Charlotte Department of Transportation

Memorandum

Subject: Rezoning Petition 08-126: Located on the north side of Wilkinson Boulevard between Holton avenue and Crispin Avenue (*revised 9/16/08*)

**SITE PLAN**  
 1"=10'-0"

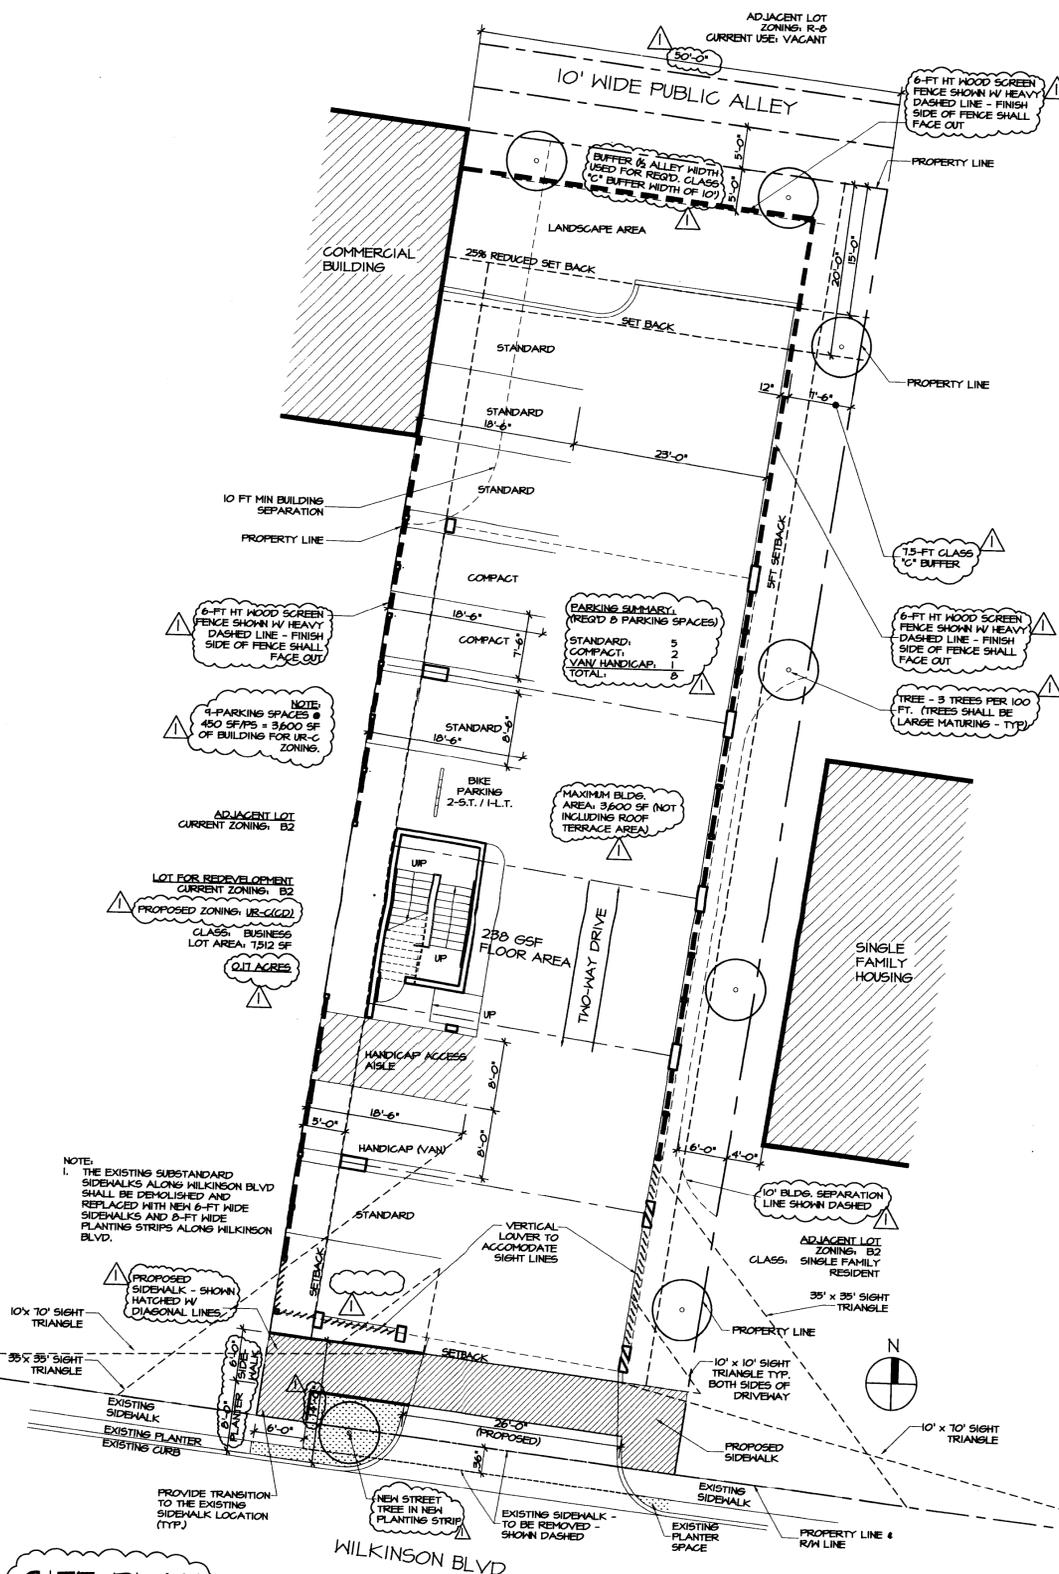
1. The parking stall illustrated in the site plan must be adjusted or removed to preserve the 10' x 10' sight triangle.
2. The fence and vertical louvers must be adjusted or removed to preserve the 35' x 35' sight triangle.

1. Depending upon the configuration of off-street parking, the developer may need to construct stub driveways to the west and/or east so that this property may have future cross access with adjacent commercial uses to provide inter-connectivity and access between uses that will not require unnecessary use of Wilkinson Boulevard. (*Previous review comment*)
